Re. Walmart #835.241 located at: 400 Eubank Blvd NE

The scope of work for this Administrative Amendment review is the for the OGP parking will be added at the front of the building in existing parking spaces. This will help customers benefit from using the Online Grocery Pickup Service and it will minimize travel distance and safety of the employees.

Re: Wal-Mart at 400 Eubank Blvd., Administrative Amendment Request

Please find responses below in bold addressing the Transportation Development Comments received June 16th, 2021.

**PROPOSED  
PICKUP  
DEMOLITION  
&  
SITE PLAN**

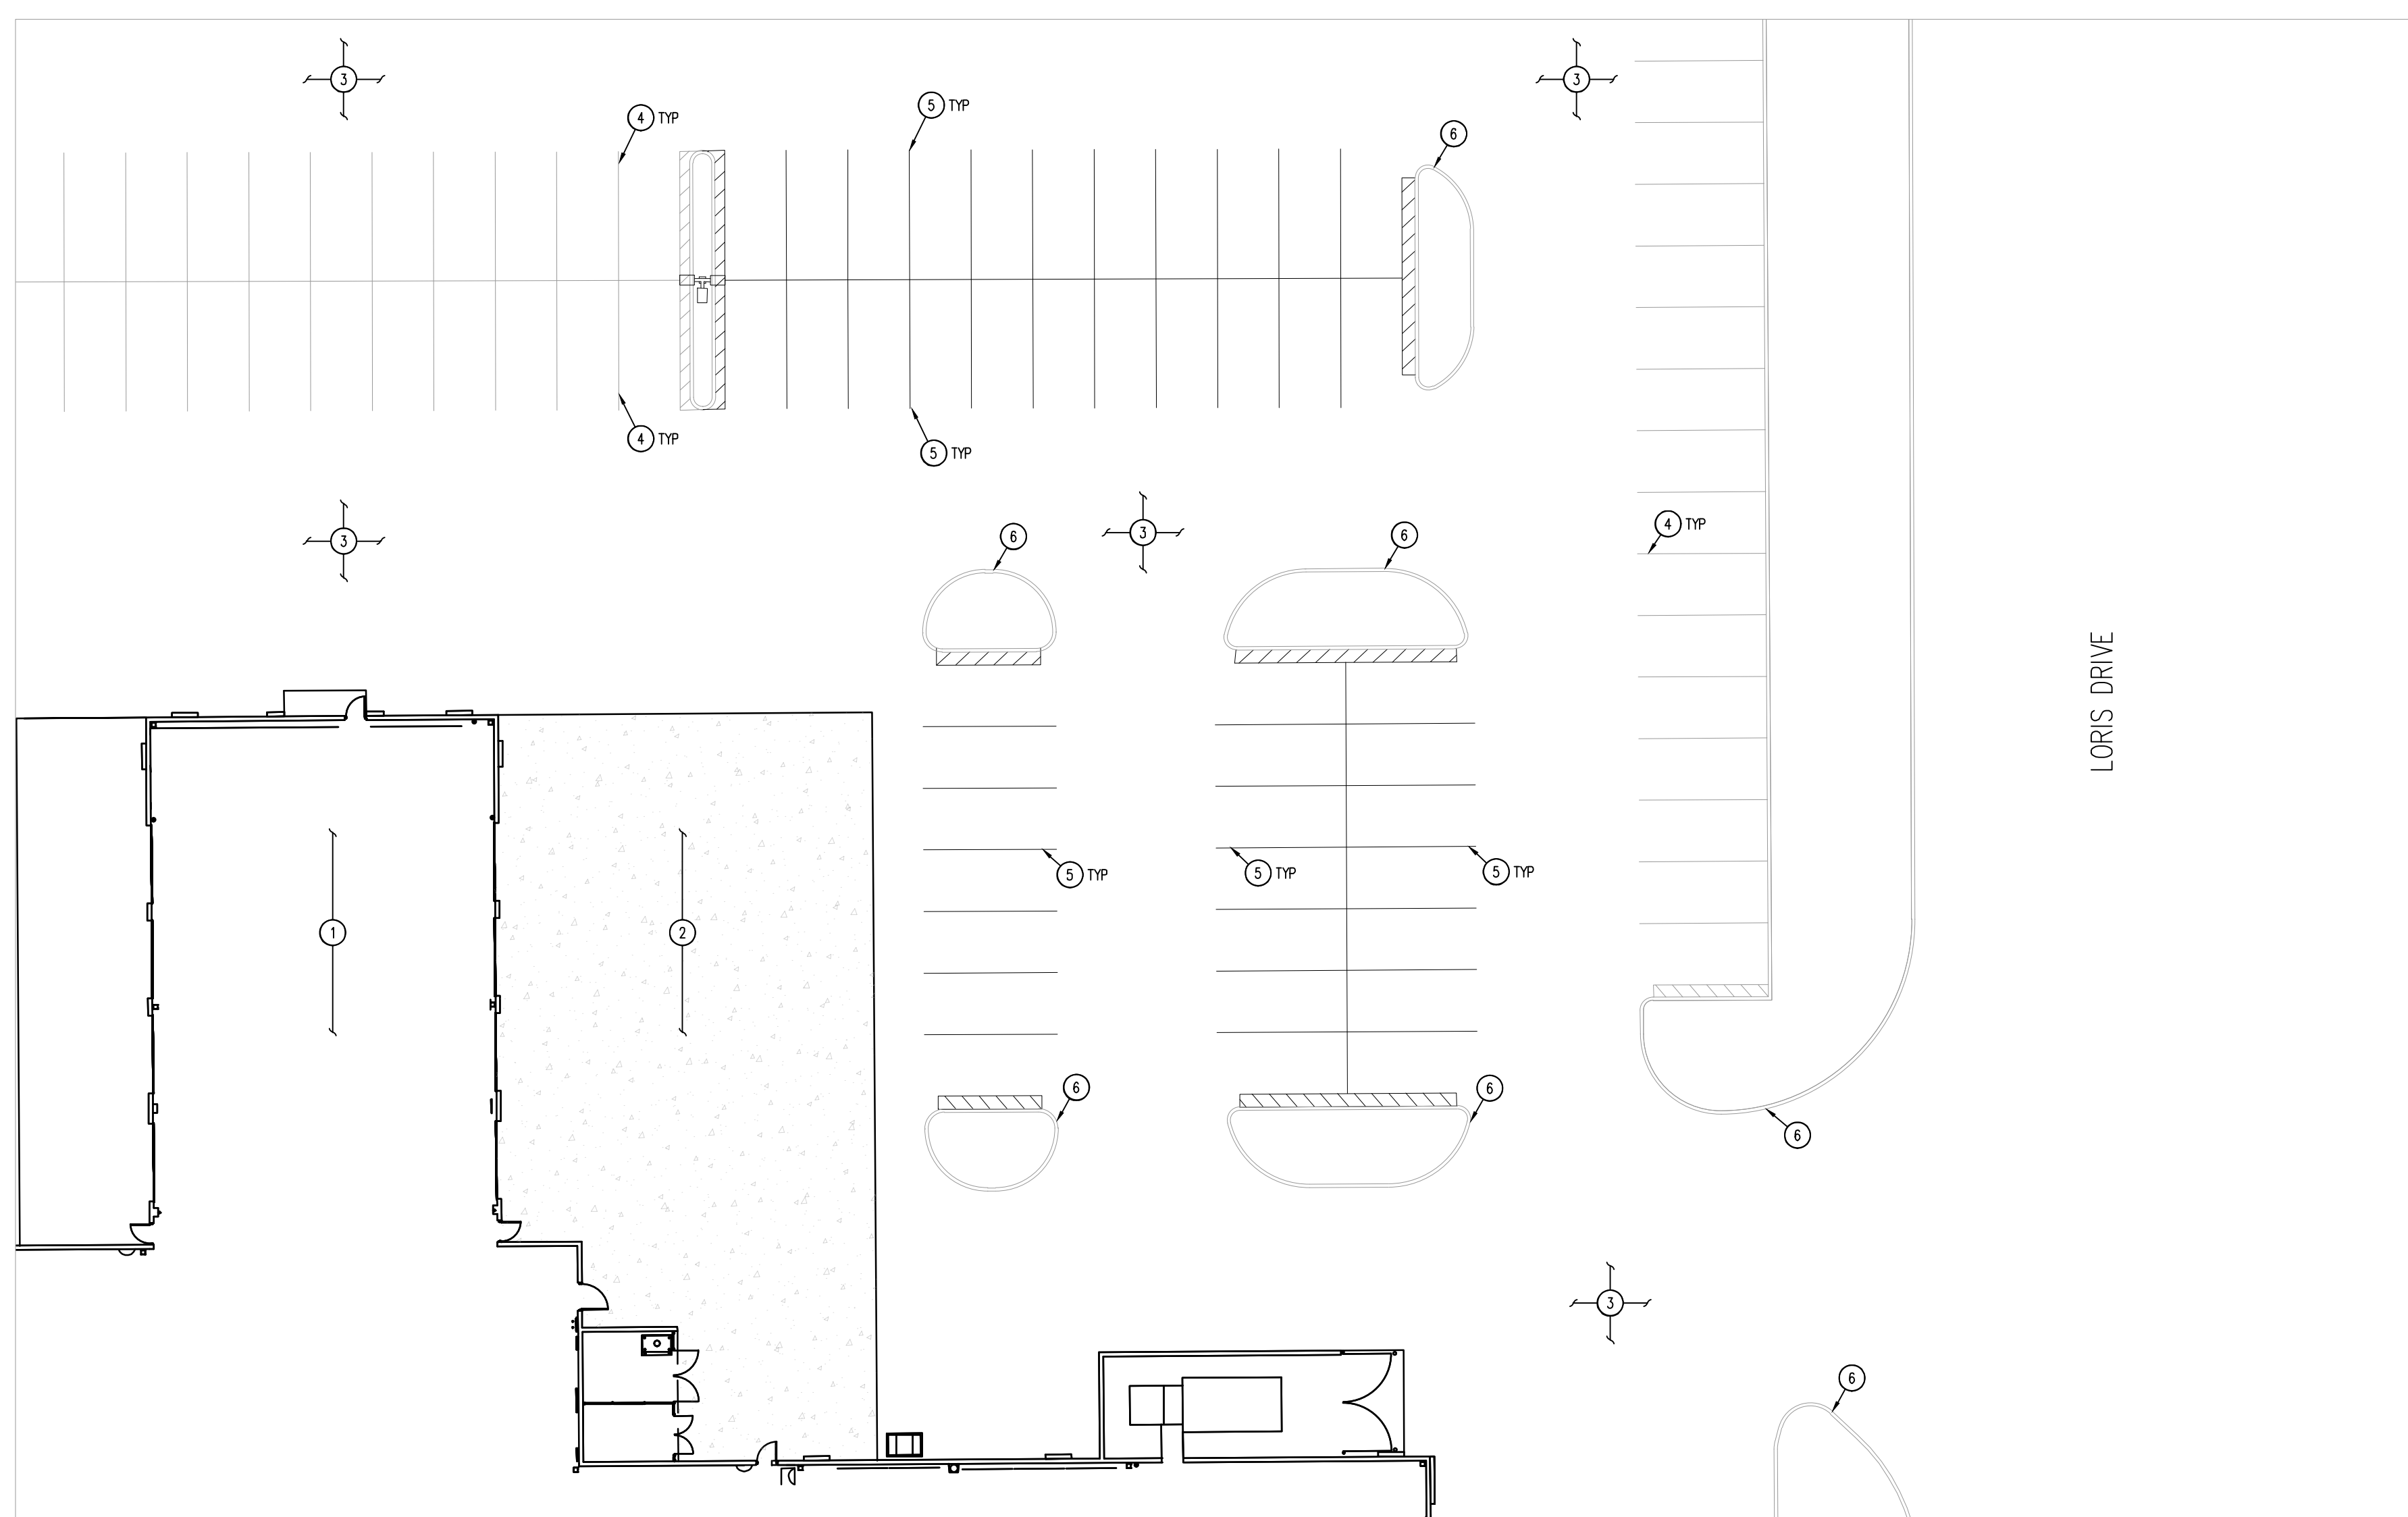
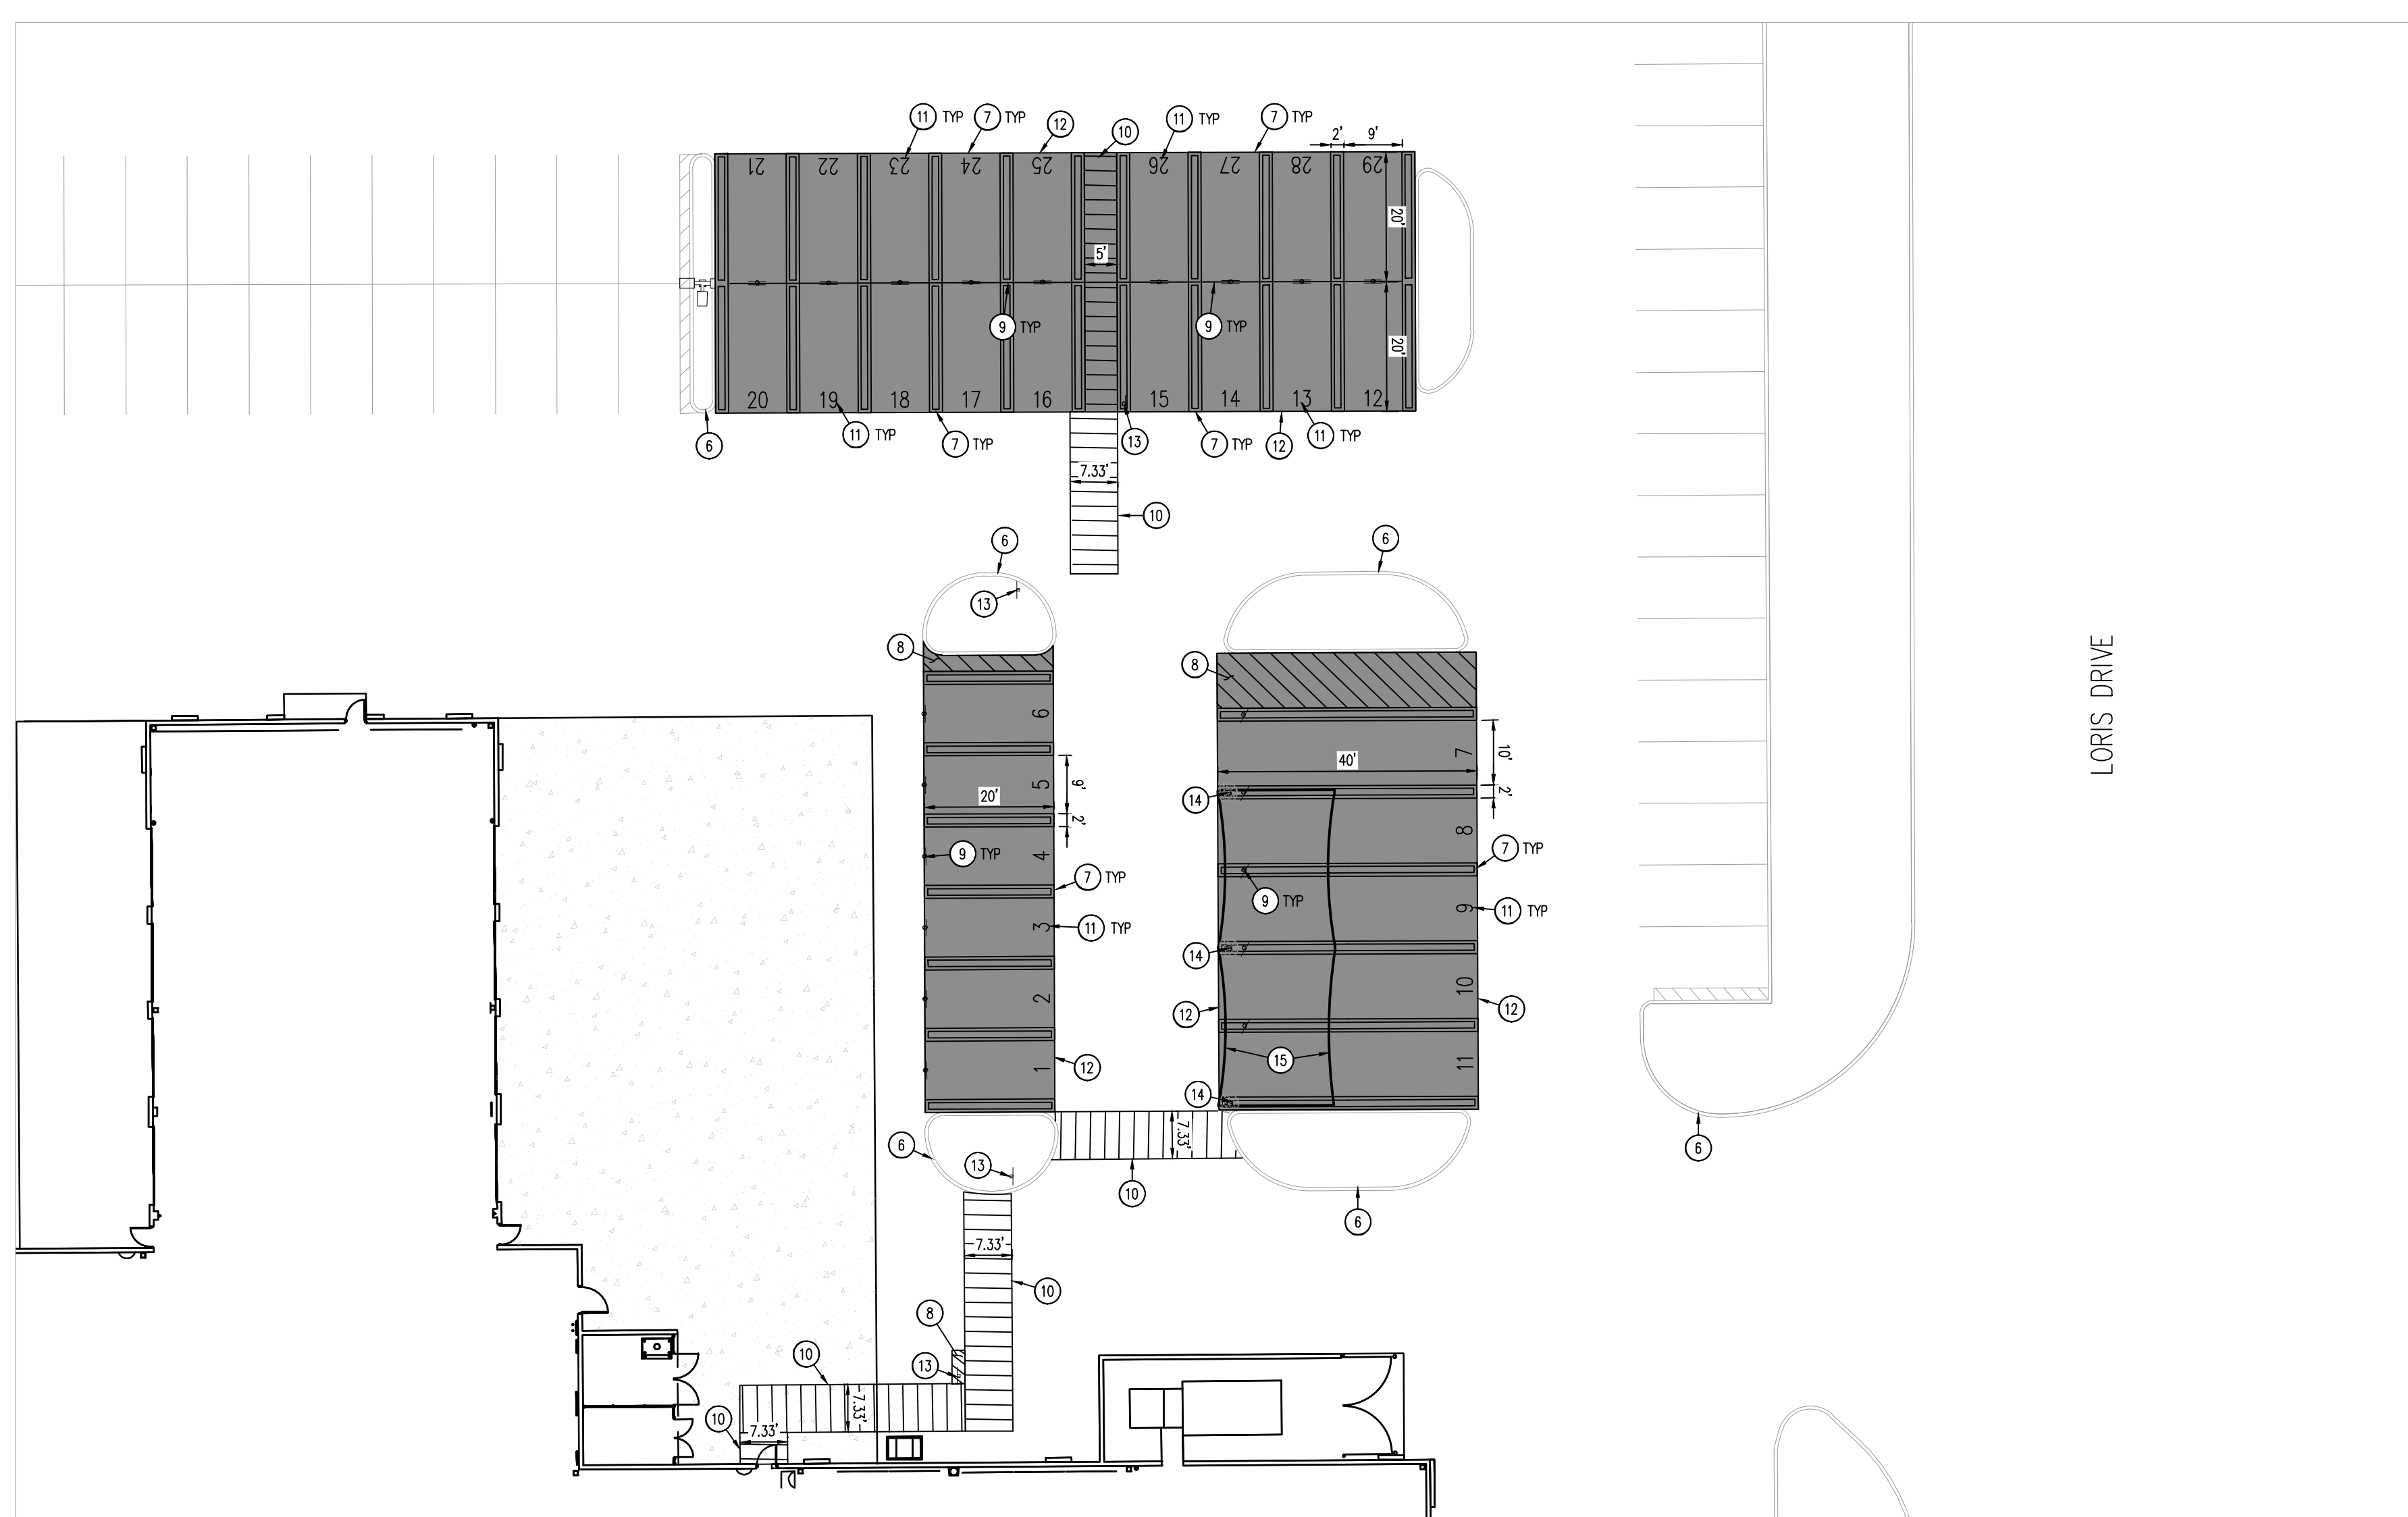
1. Since the parking calculations showed that the site barely met parking requirements originally, please update parking calculations according to the updated parking reduction count based on conversion of parking spaces to pick-up space.

2. Also, provide "Stop Here for Pedestrian" signs for the other crosswalk shown in front of the building on the new site plan for the pickup-up spaces.

Response: Parking table has been added to the plan indicating existing parking count along with revised parking count & ratios.

Response: Pedestrian crossing signage exists as you travel "north" along the front drive aisle. A new pedestrian crossing sign and post has been added in the landscape area prior to the crosswalk heading "south" along the front drive aisle.
